Reference: PO/8/26/DOC

Address: St Johns Priory Poling Street Poling BN18 9PS

Proposal: Approval of details reserved by condition imposed under reference PO/2/26/L, relating to condition no. 4 - repointing.

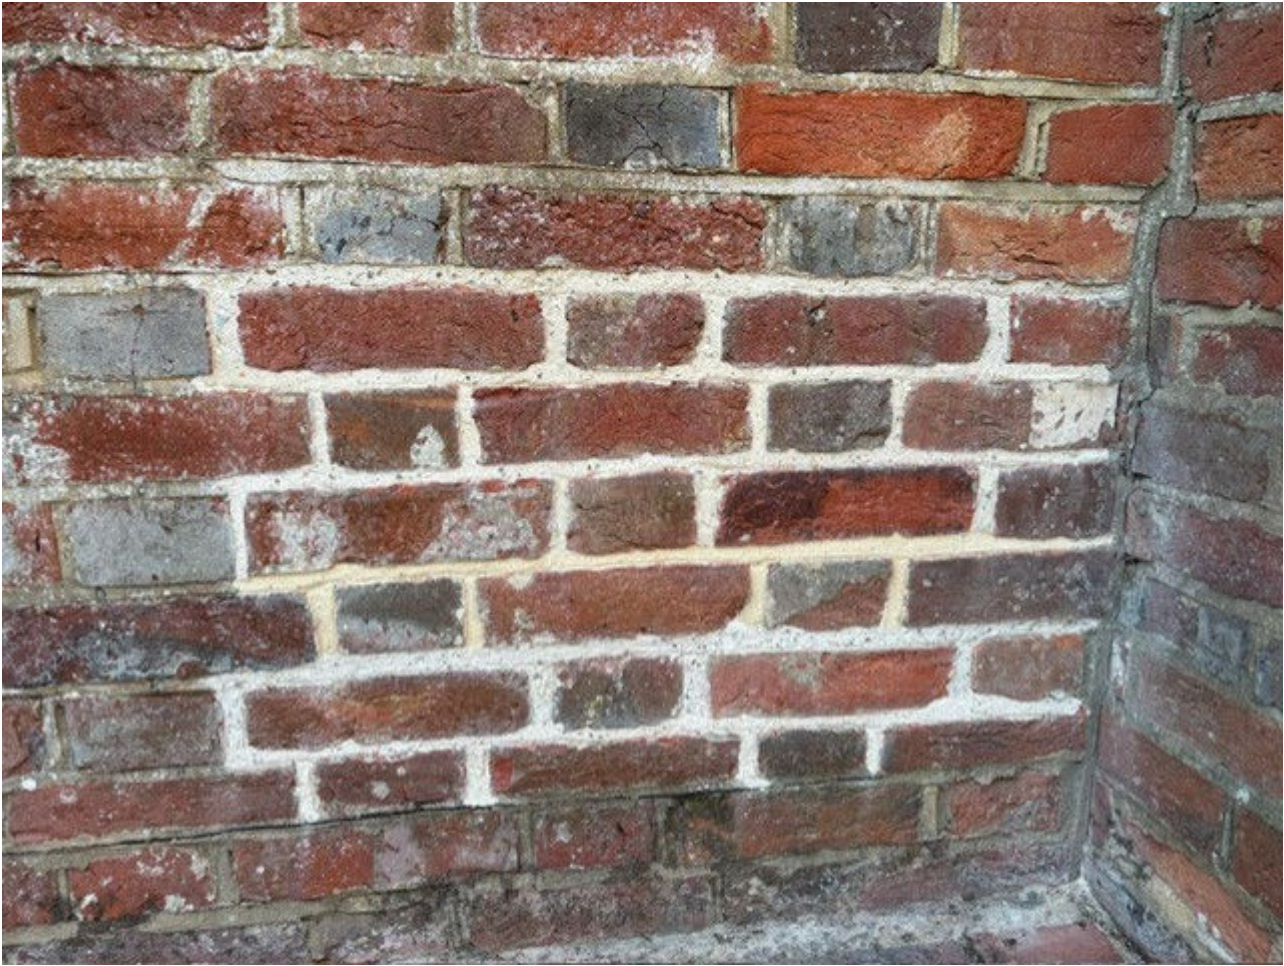
Comments: Sadly, I am unable to locate any photographic information on the application file. You may wish the agent to provide a photograph of the sample panel. However, I have visited the site and viewed the sample panel, which included a number of options. I met with the contractor, and we agreed that options A and B were acceptable.
Based on the above, the condition can be discharged.
